Application no: **3/2021/1181**

Address: **8 Whittam Road Whalley BB7 9SB**

Proposal: **Resubmission of planning application no. 3/2021/0217 with design amendments for the erection of a two storey side and rear extension with a single storey element to the rear and associated alterations.**

The Local Highway Authority have viewed the plans and highway related documents and have the following comments to make:

PROPOSED SITE PLAN
Scale 1:100

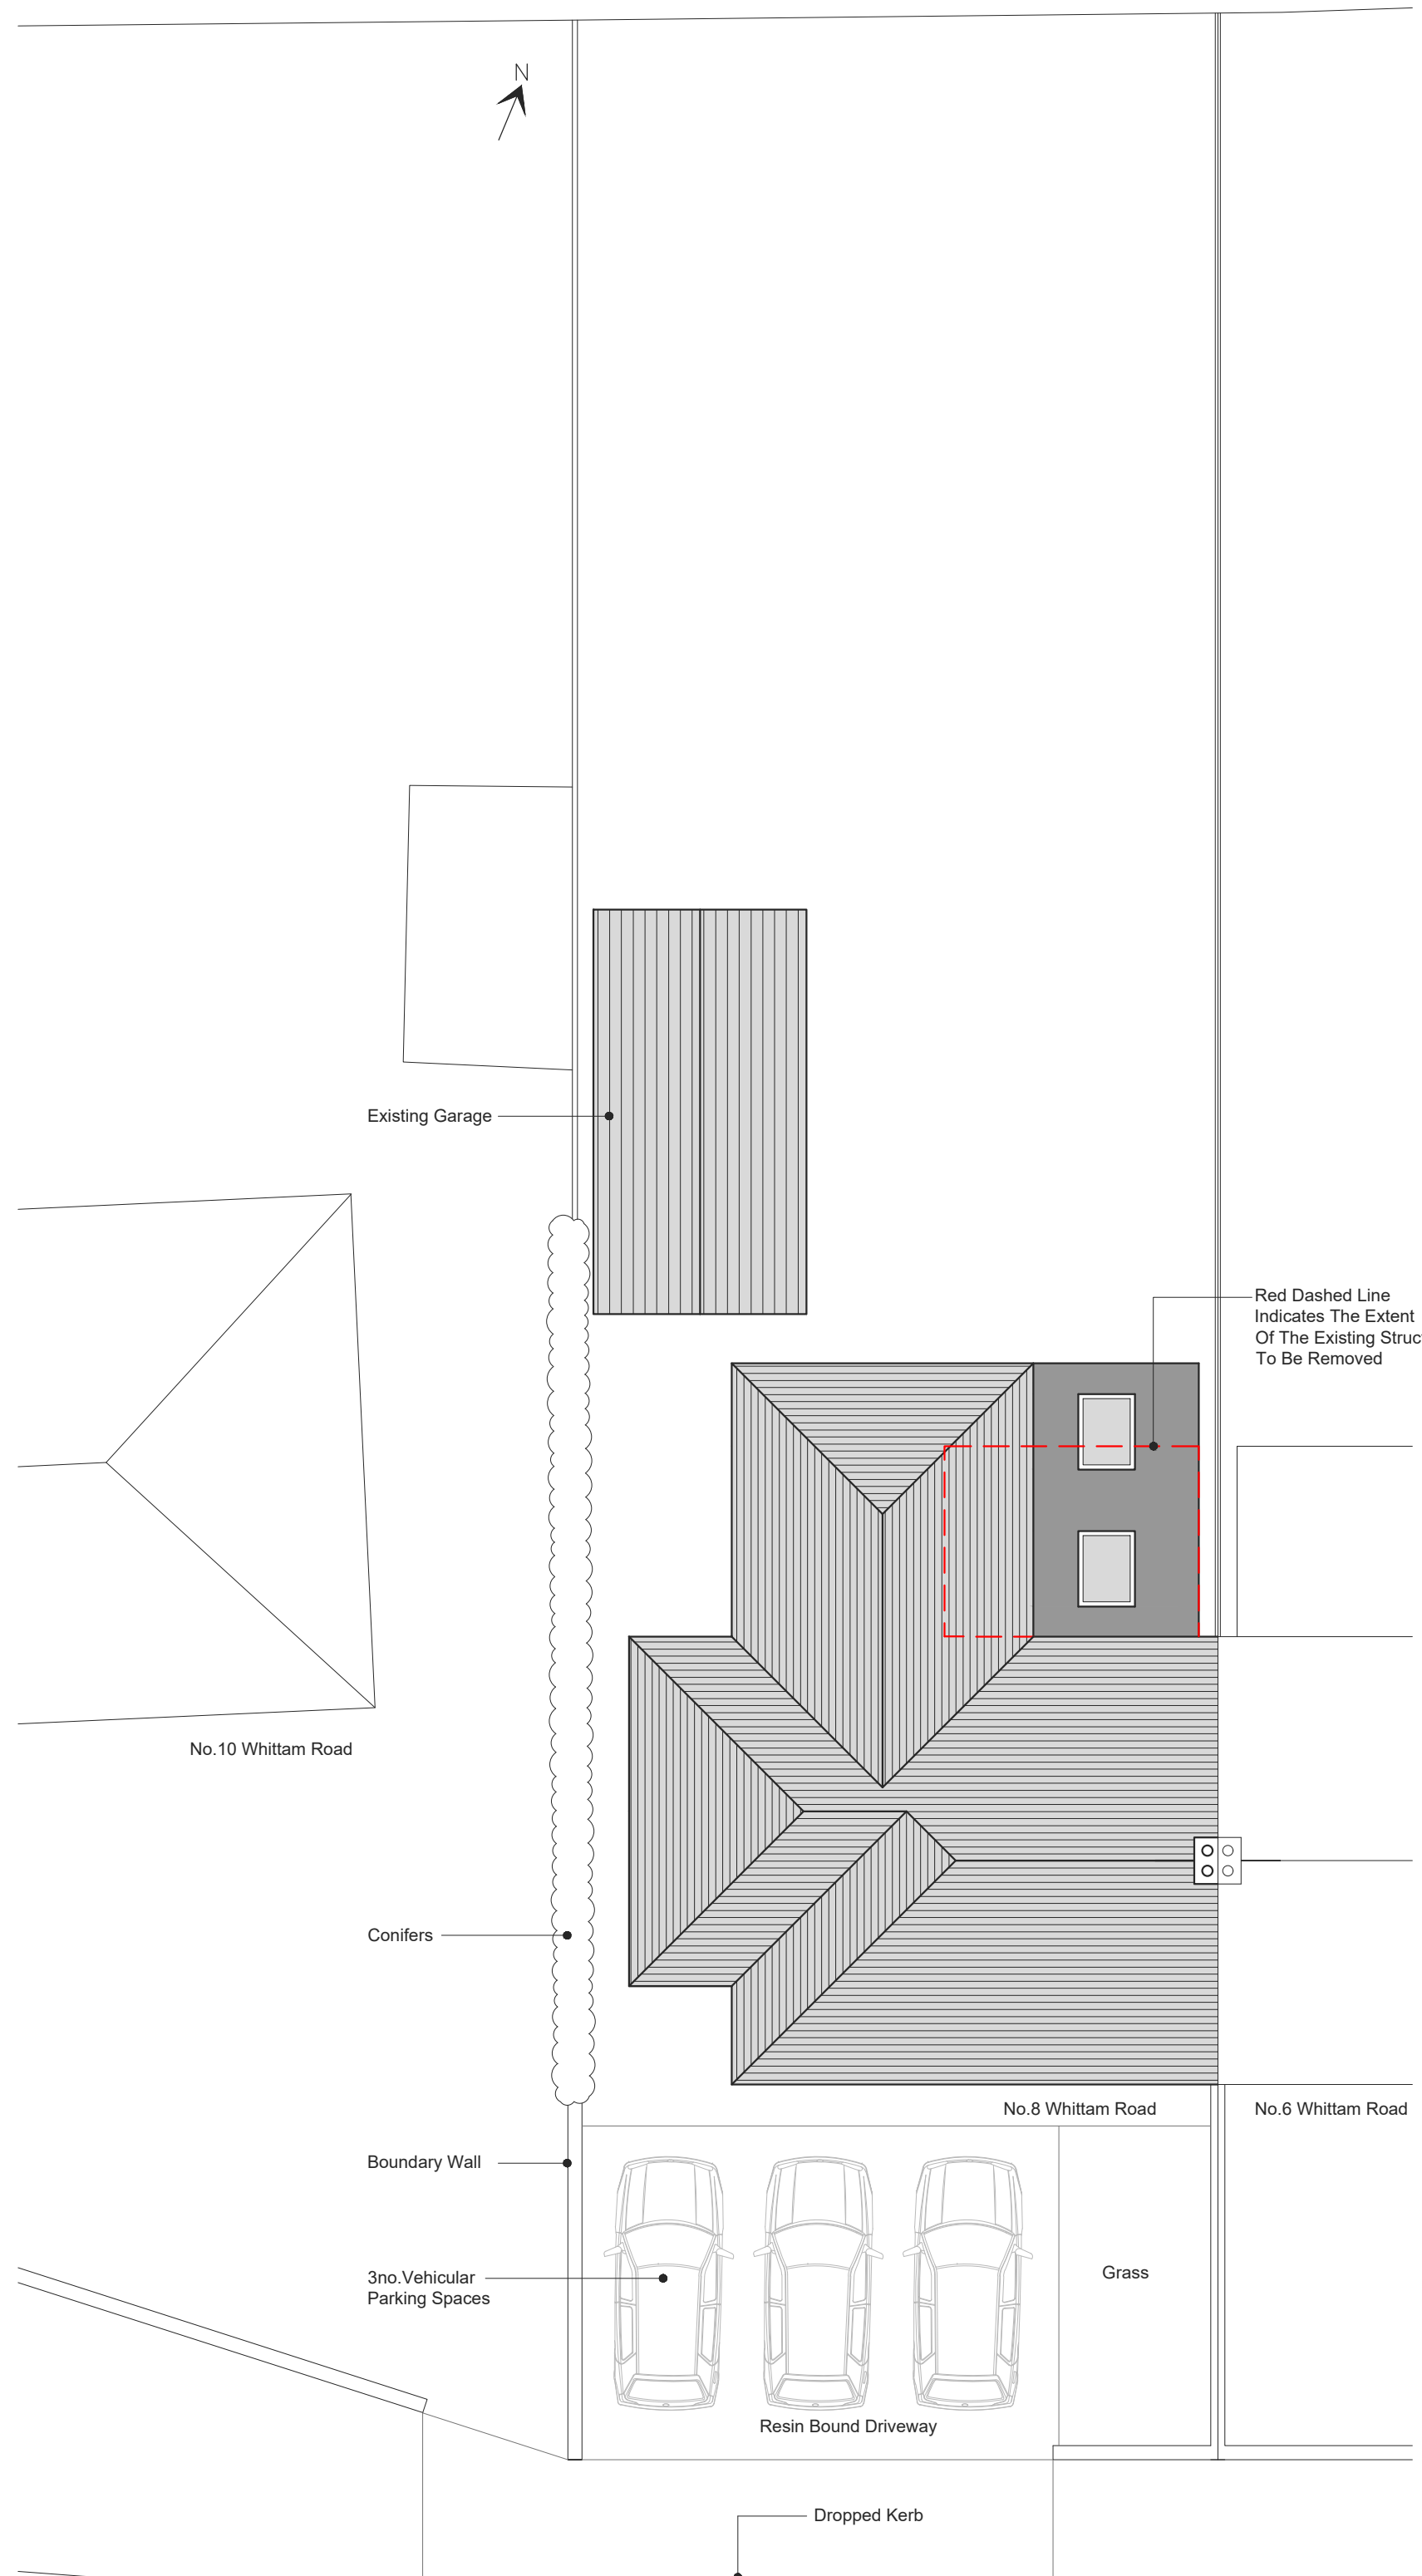
to comply with the parking standards as defined in the Joint Lancashire Structure Plan, the LHA require 3 parking spaces to be provided.

The LHA have reviewed RVA drawing number WR-02 Rev A titled "Proposed Plans and Elevations" and understands that the site can provide 3 parking spaces. Therefore, the site complies with the LHAs parking standards and so the LHA have no objection to the proposal.

1. The development hereby permitted shall not be occupied until such time as the parking and turning facilities have been implemented in accordance with RVA drawing number WR-02 Rev A. Thereafter the onsite parking provision shall be so maintained in perpetuity.
